2003 PLAN REVIEW RECORD

JURISDICTION: PORTLAND (City, County, Township, etc.)  
 BUILDING LOCATION: 57 FREDERIC ST (Street address)  
 BUILDING DESCRIPTION: 3 STORY 20 UNIT BUILDING

Plan Review # 050452  
 Date: 5/12/05  
 Valuation: \_\_\_\_\_  
 Fee: \_\_\_\_\_

CORRECTION LIST

14 BOX-OUT DUCT @ CORRIDOR (TYP.)
 SCALE: 3/8" = 1'-0"

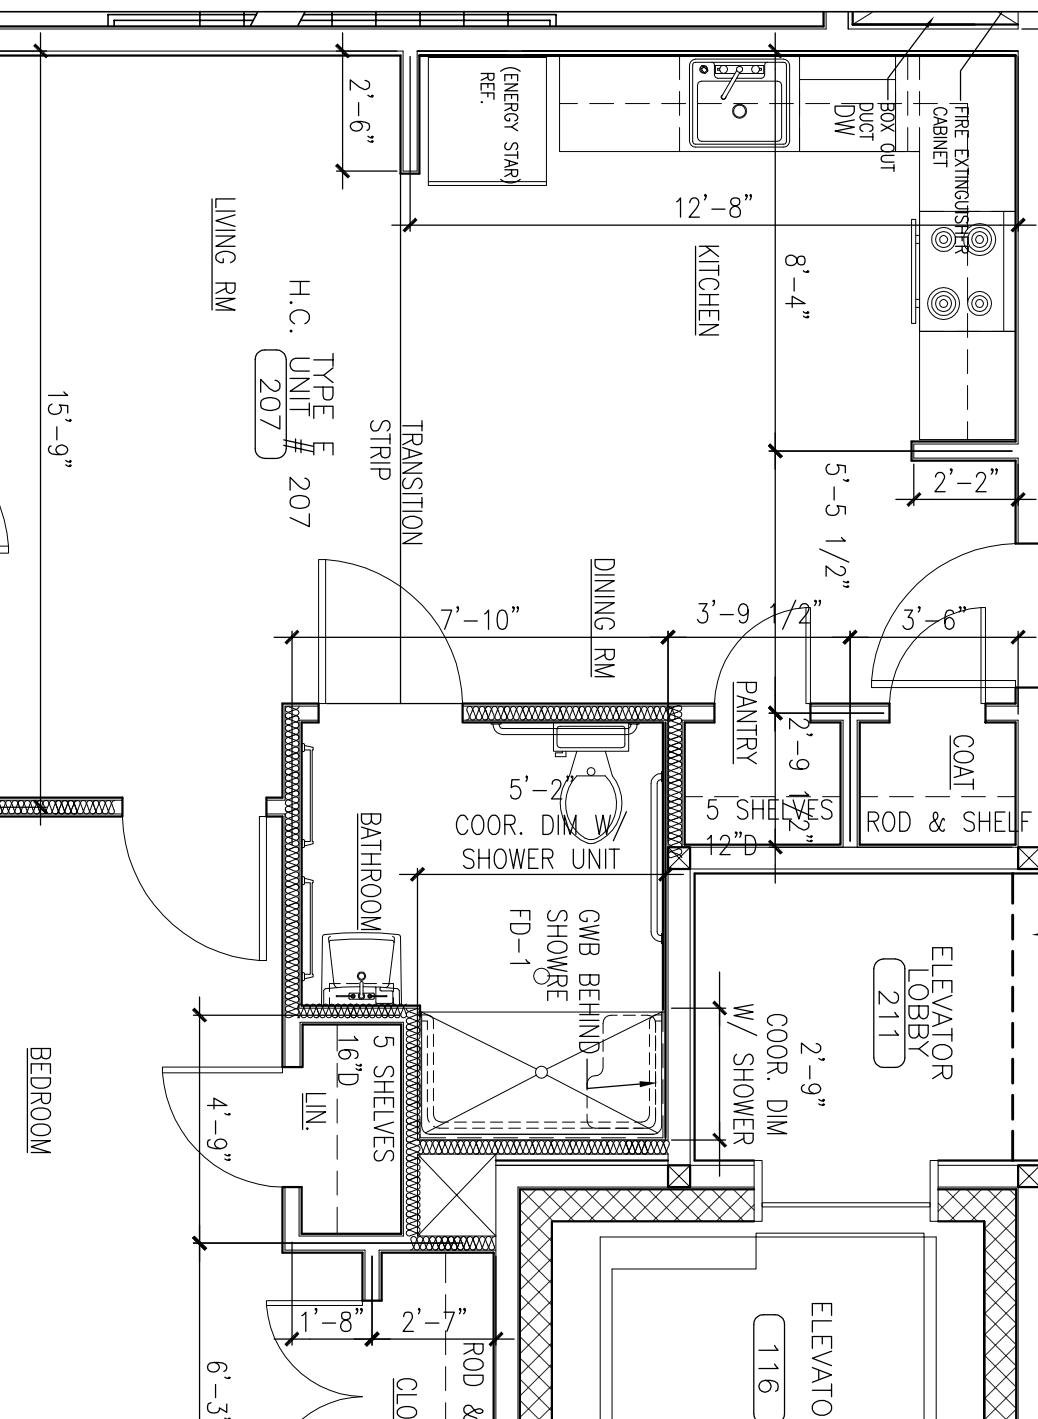
| No. | DESCRIPTION  | Code Section |
|-----|--|--------------|
|     | WHY IN THE DUCT CHASE NOT (WALL TYPE 6) RATED?                     |              |
